# Charlotte Department of Transportation

## Memorandum

**Date:** July 2, 2008

**Subject:** Rezoning Petition 08-070: Located in the block bounded by North Davidson Street, East 26th Street, East 27th Street & Yadkin Avenue (revised 6/20/08)

DATE: January 3, 2008  
 DESIGNED BY: CCM  
 DRAWN BY: SK  
 CHECKED BY: CCM  
 SCALE: 1" = 40'  
 PROJECT #: 1007324  
 SHEET #:  
**RZ-1.0**

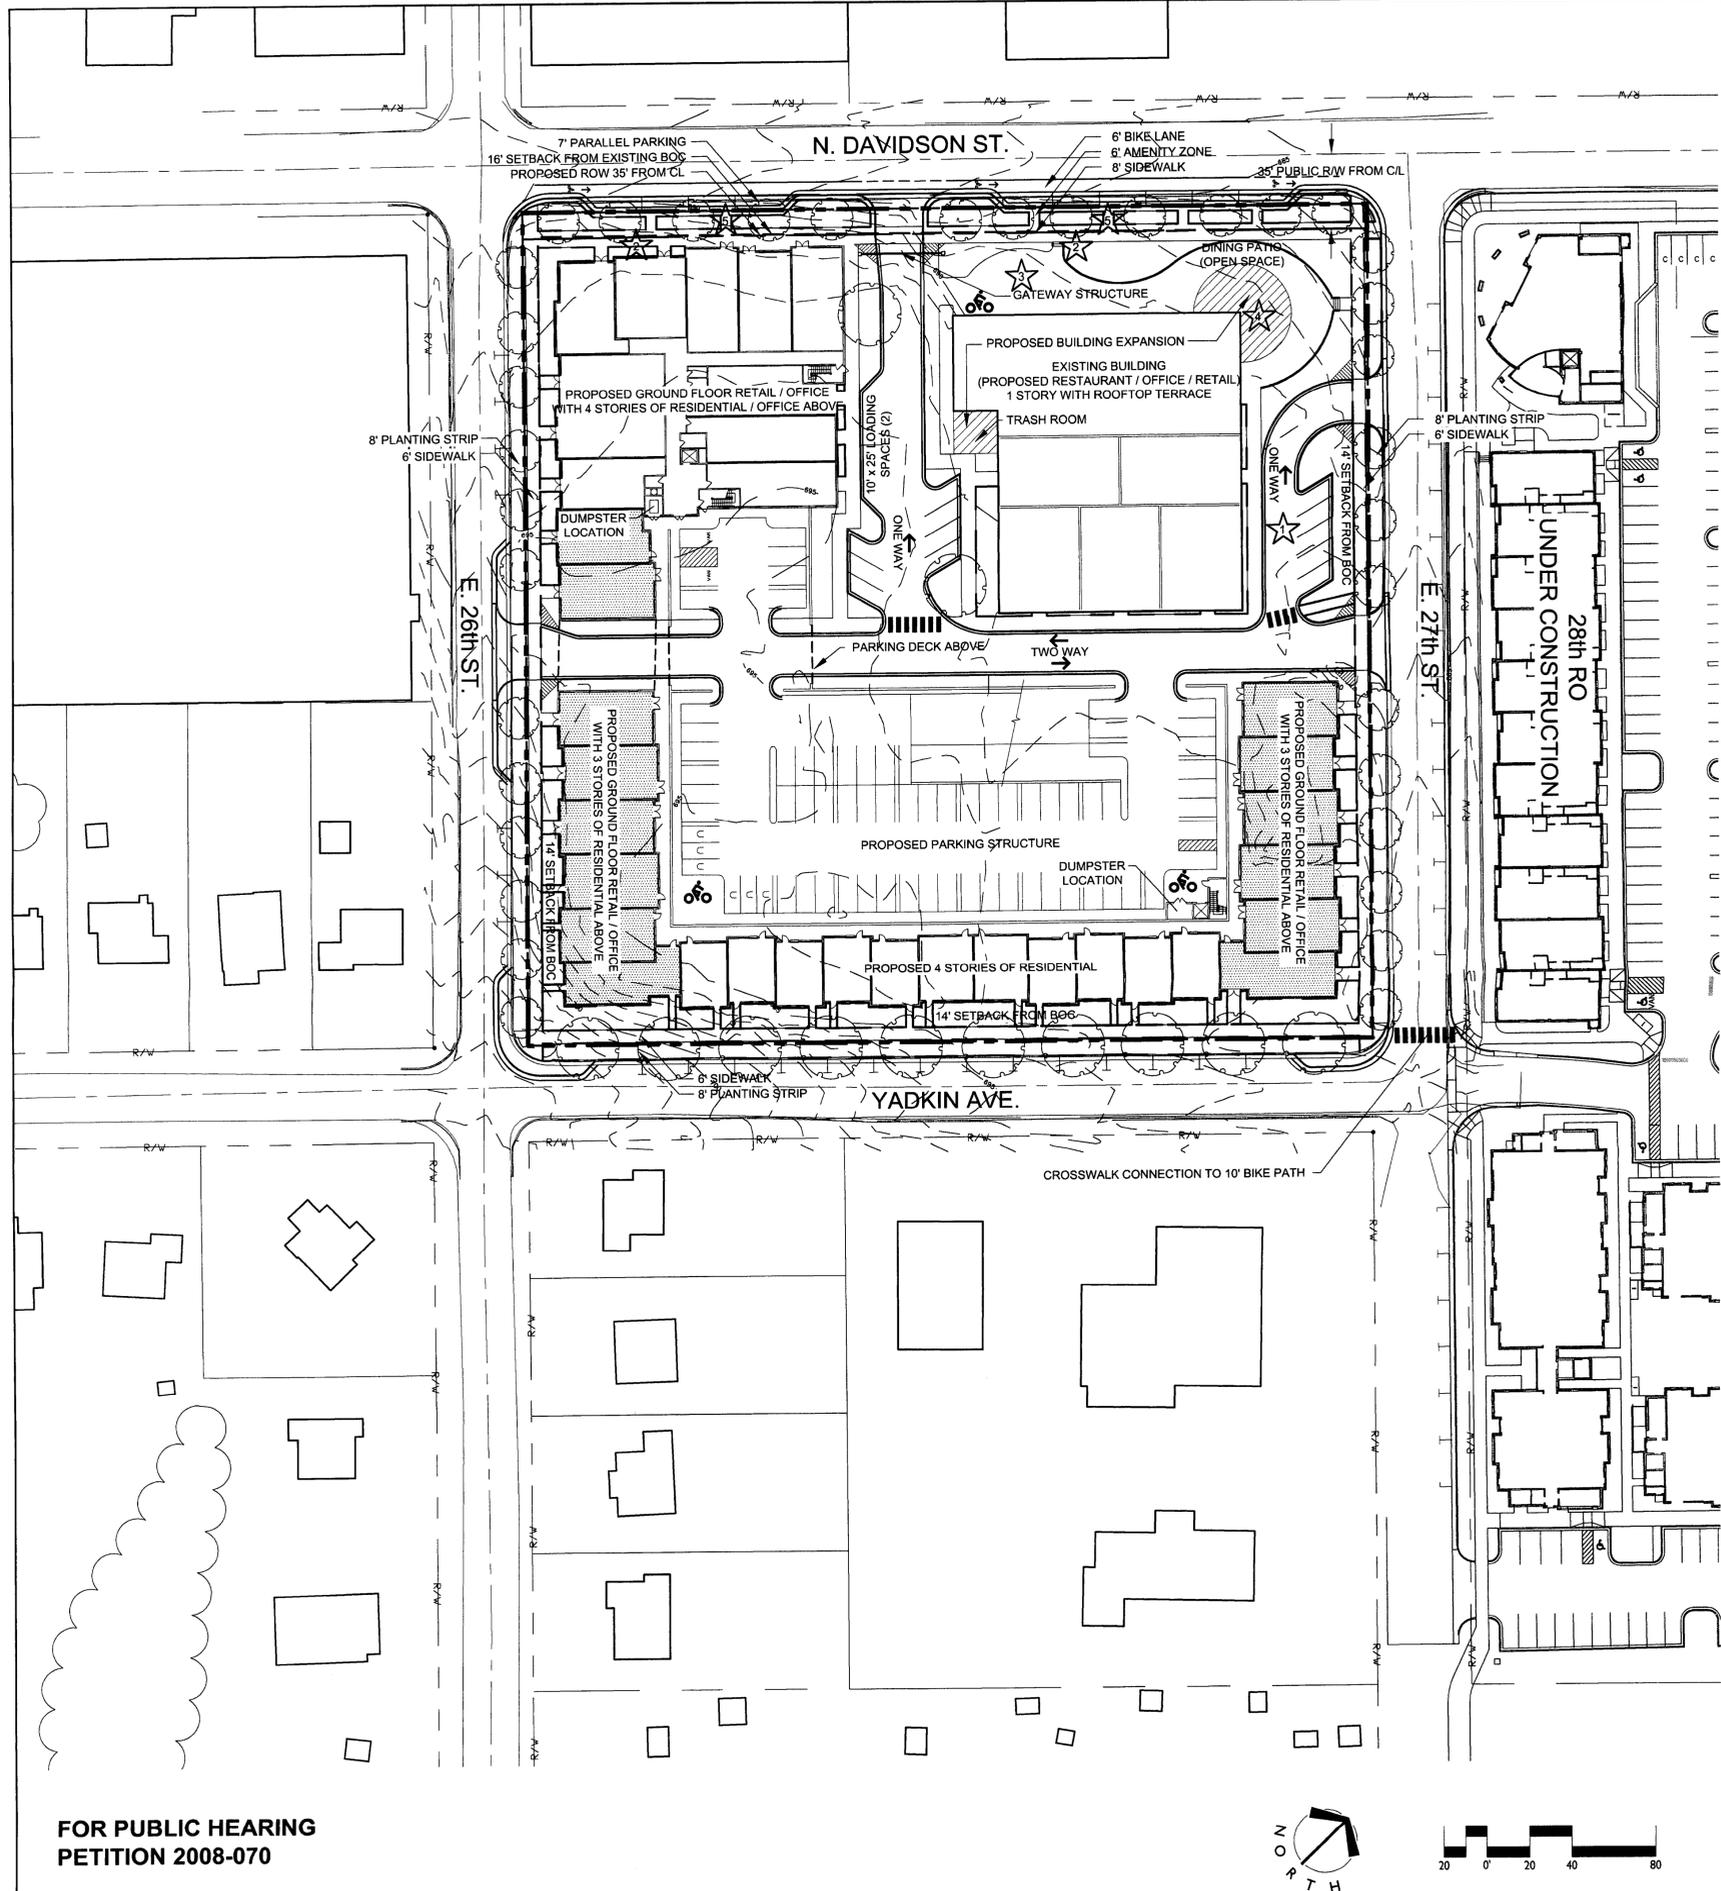
2. As discussed with the petitioner, the residential wide cross section (USDG) needs to be used where parking is to be accommodated on the street. The face of the proposed curbline on both E. 26<sup>th</sup> Street and Yadkin Avenue needs to be located a distance of 17 feet from the existing centerline of the street. This will provide a 7-foot parking lane adjacent to the curbline. The curbline cannot be recessed or parking permitted on E.26<sup>th</sup> Street within 100 feet of N. Davidson Street. The site plan needs to be revised accordingly.

3. The extended curblines at the 26<sup>th</sup>/Yadkin and 27<sup>th</sup>/Yadkin intersections must provide at least for an 11-foot travel lane (centerline to lip of gutter) and may be increased to accommodate turning movements for Single Unit design vehicles. These design issues will be reviewed during the building permit plan review process.
